Drawing  
**TREE REMOVAL & ARBORICULTURAL IMPACT  
 ASSESSMENT PLAN**

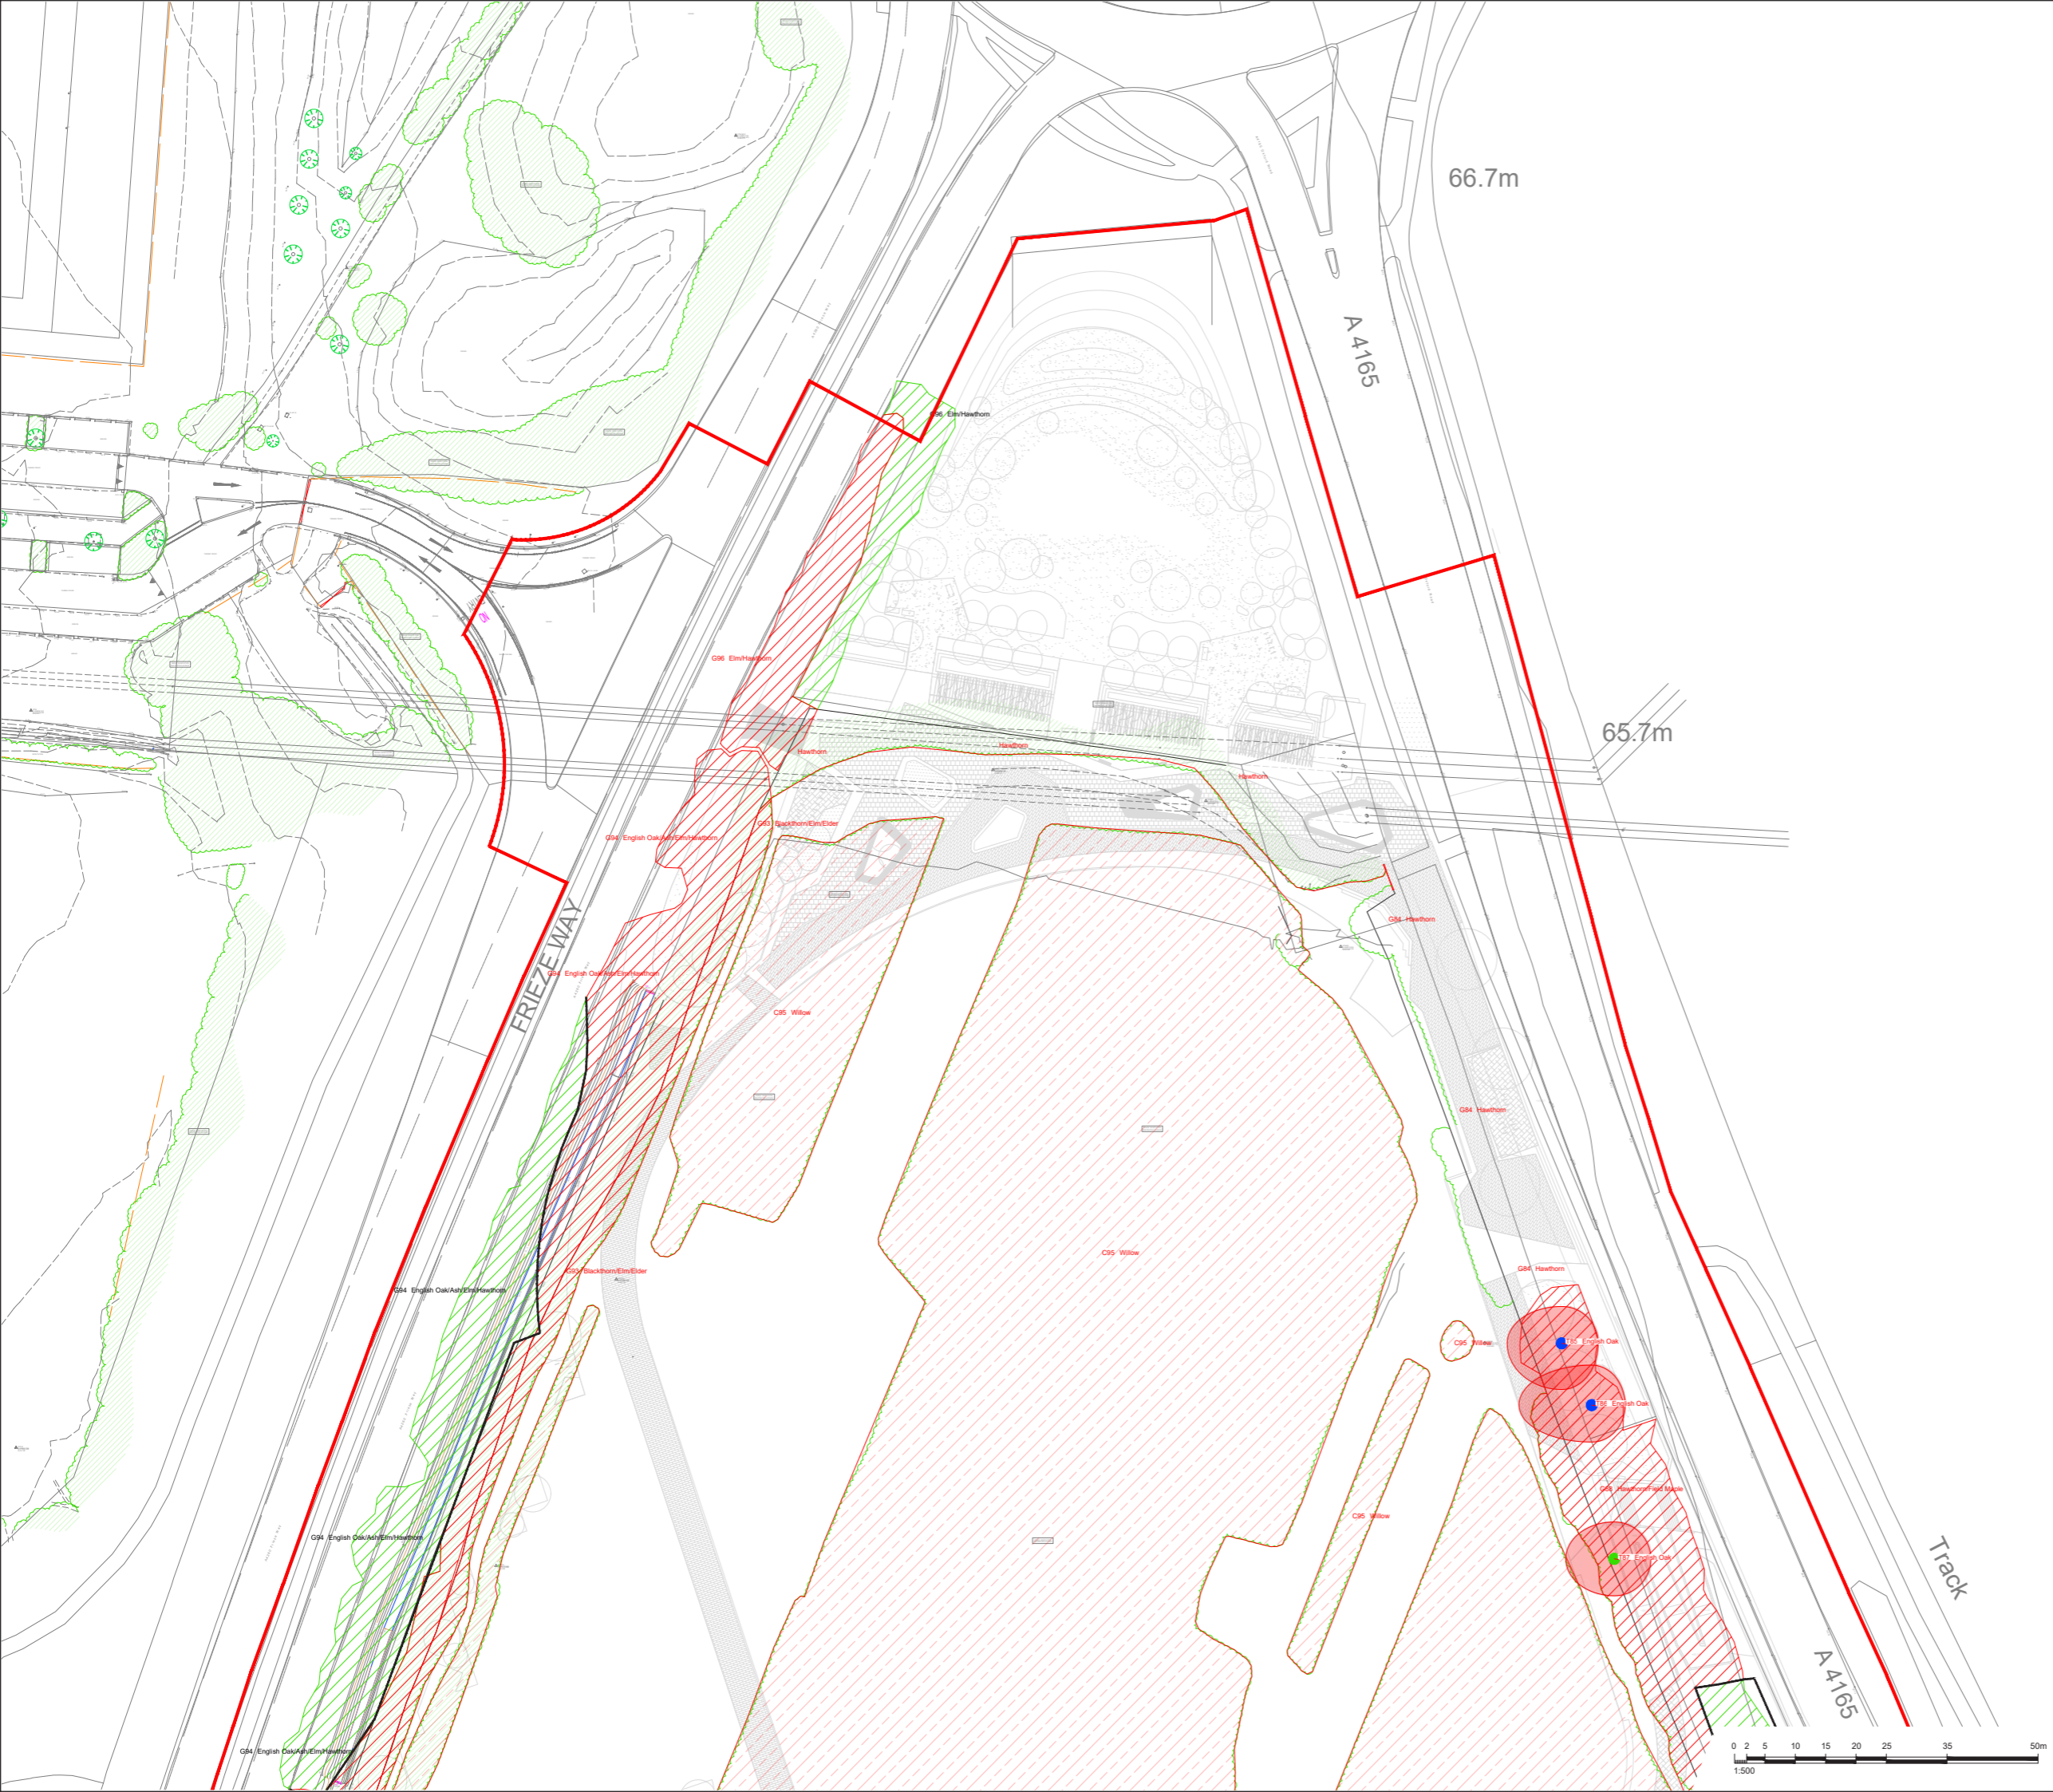
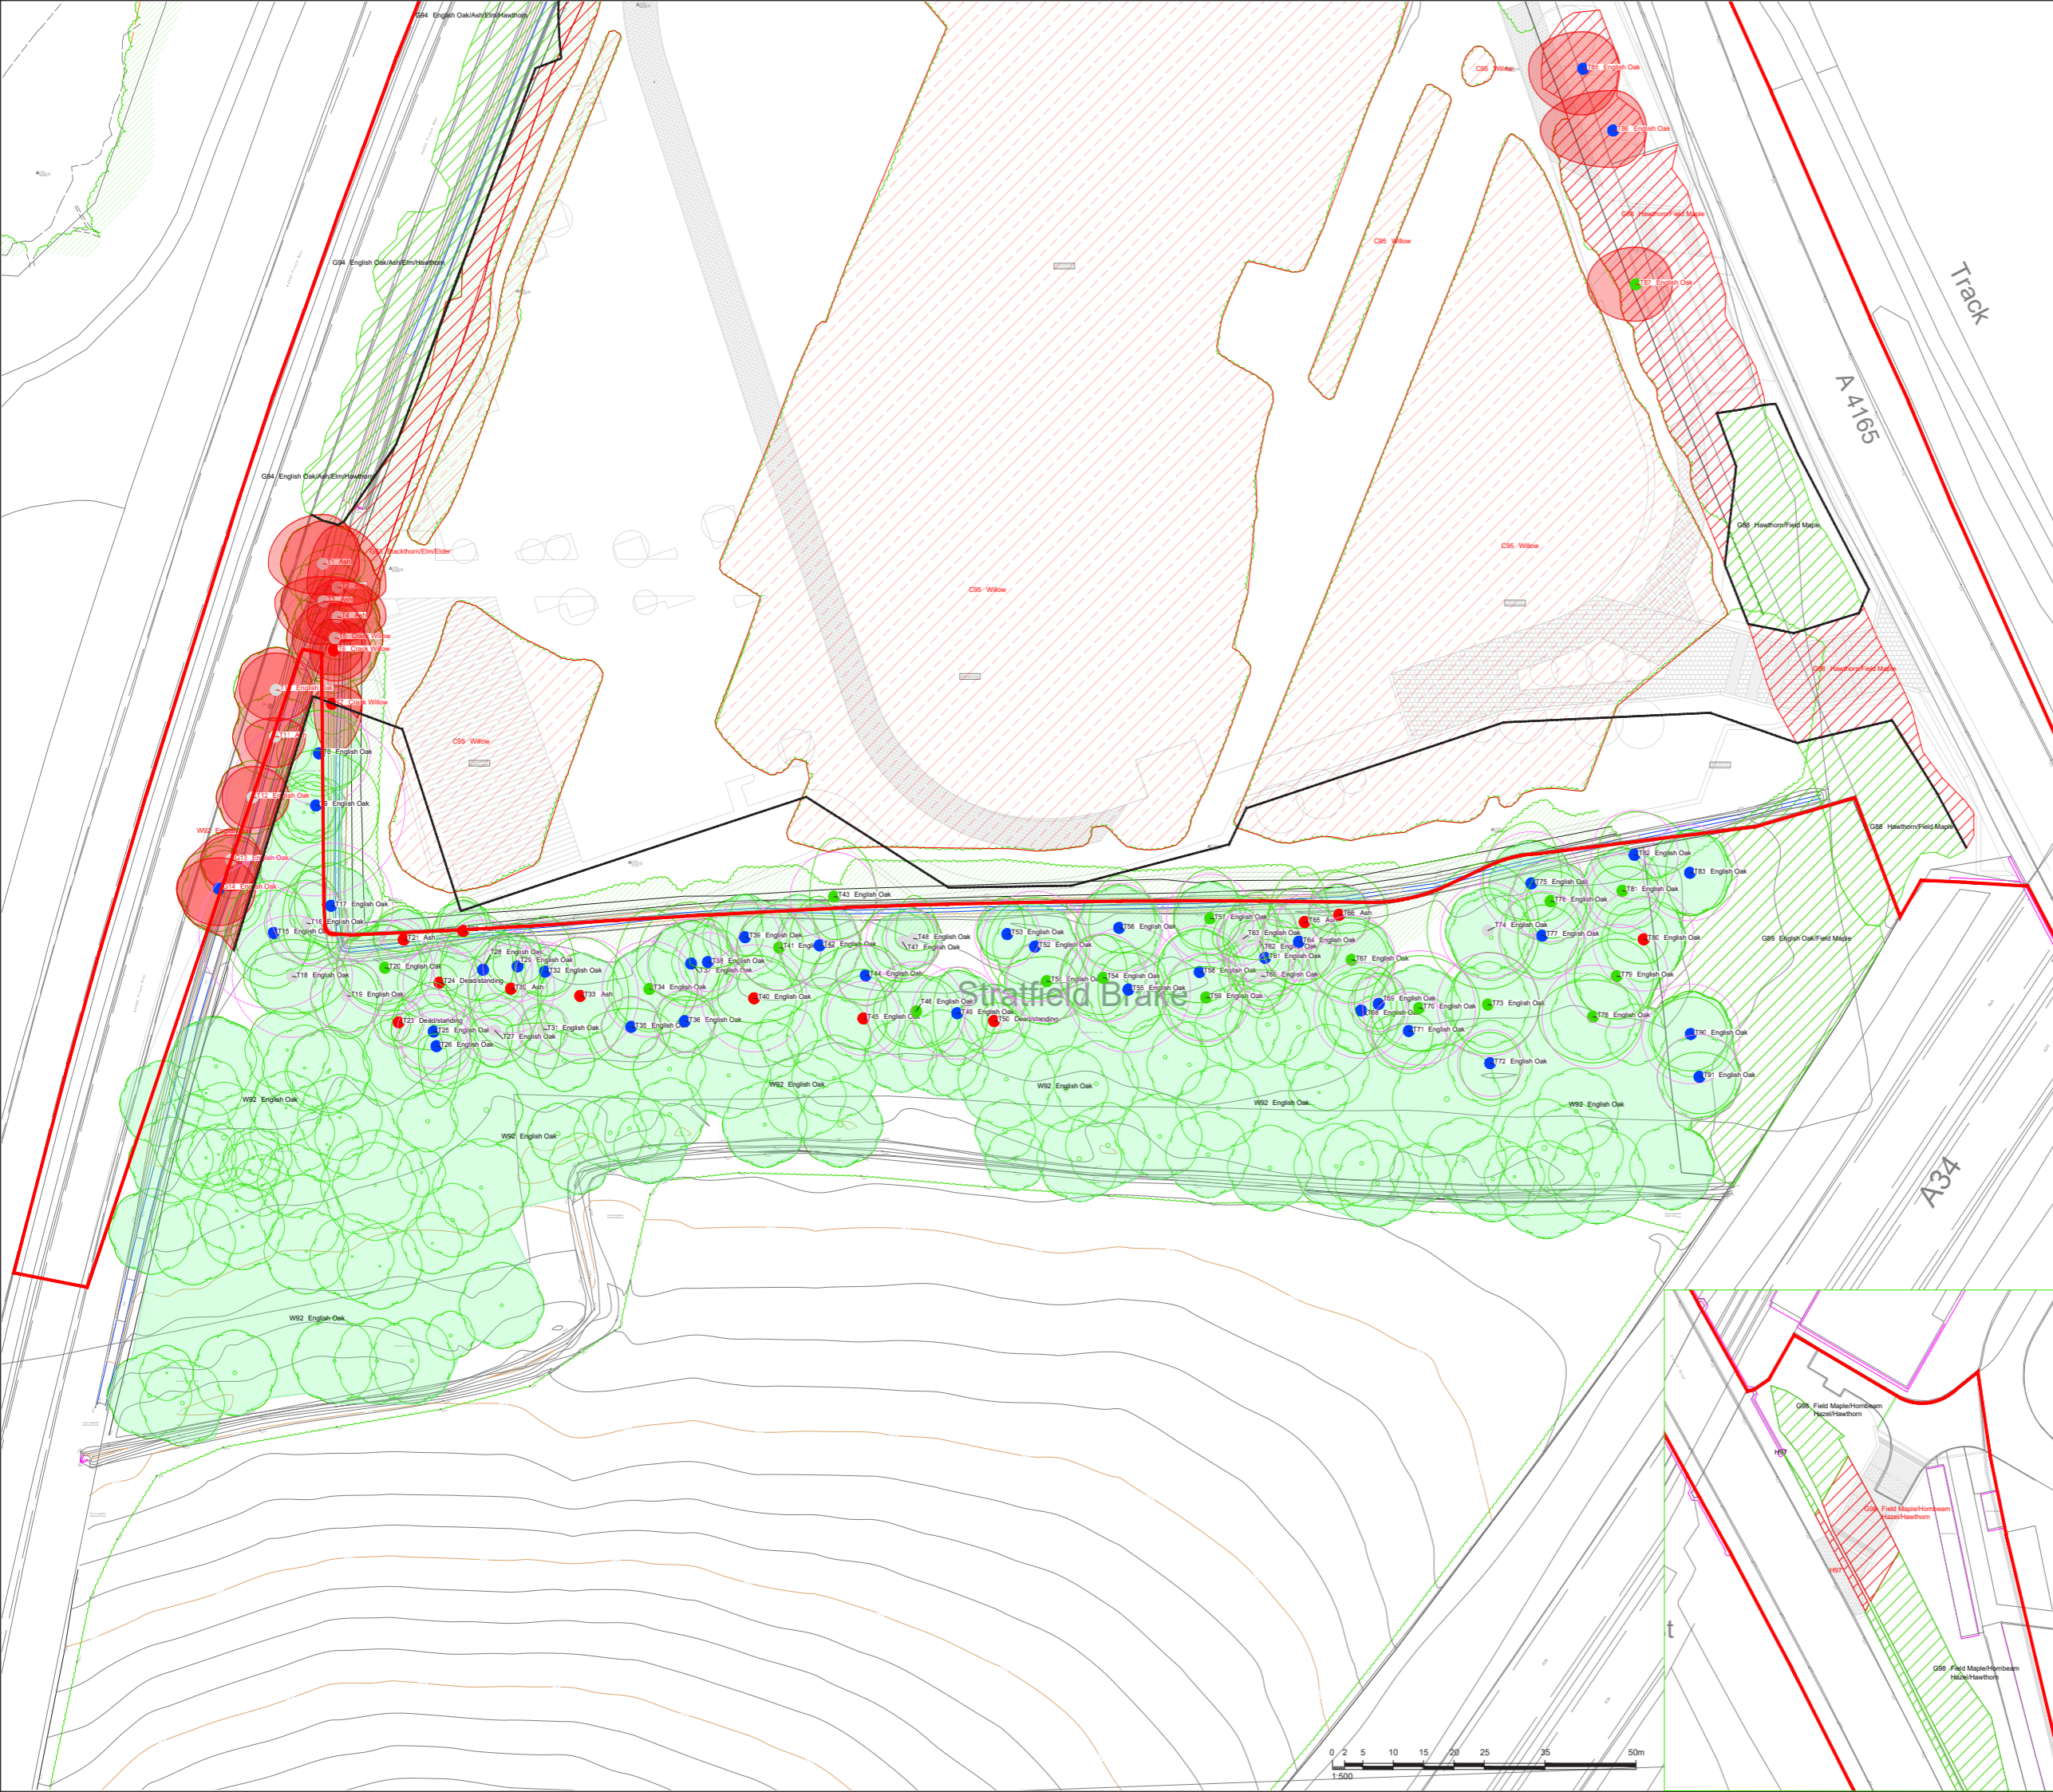
I note that the plans suggest that the line of trees that continue the sequence that has been preserved within the roundabout as a result of objections to their removal will be removed -

drawing title
Proposed Site Elevations

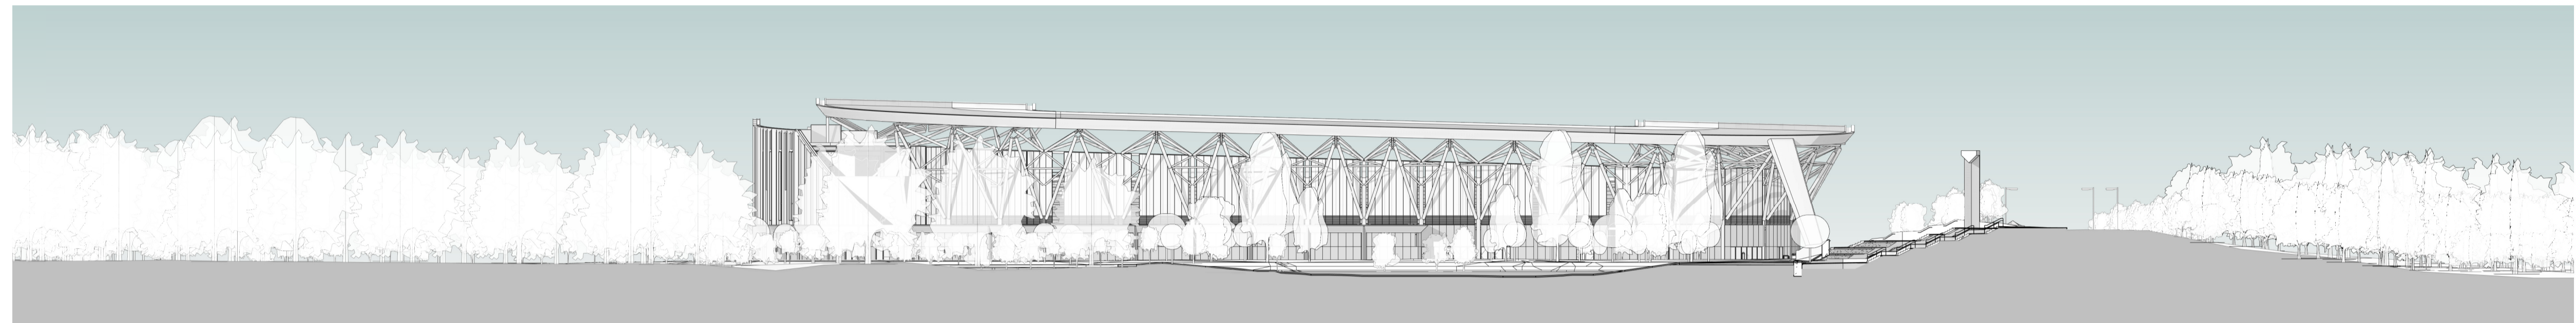
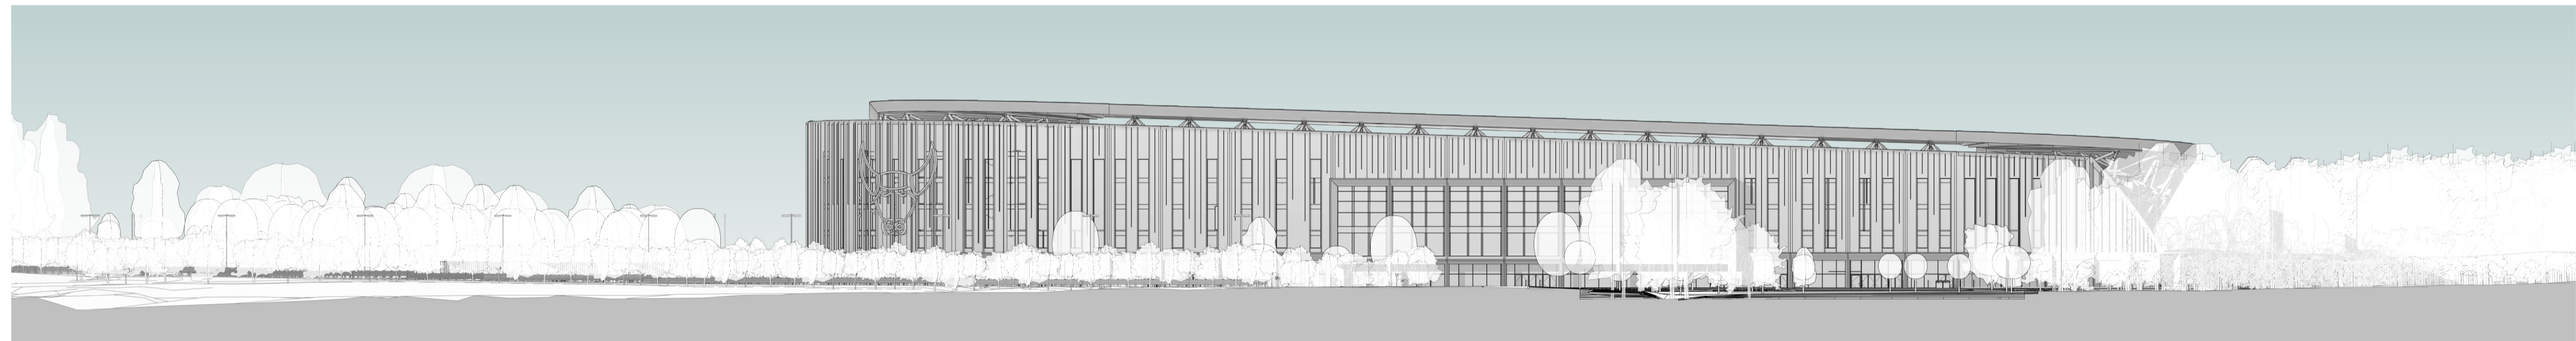
I have referred to mass above. This will dominate the site and form a far more overpowering presence than the artist's impression indicates since it will be the pre-eminent "impression of Kidlington" as one approaches from the south and crosses the bridge across the railway and the A34. Unfortunately, the stadium is being compressed into a tight site and the overall development is for more than a stadium alone. Thus the road immediately around the proposed stadium is pressed against the boundaries of the site, with the only relief being the far north tip of the site into the roundabout.
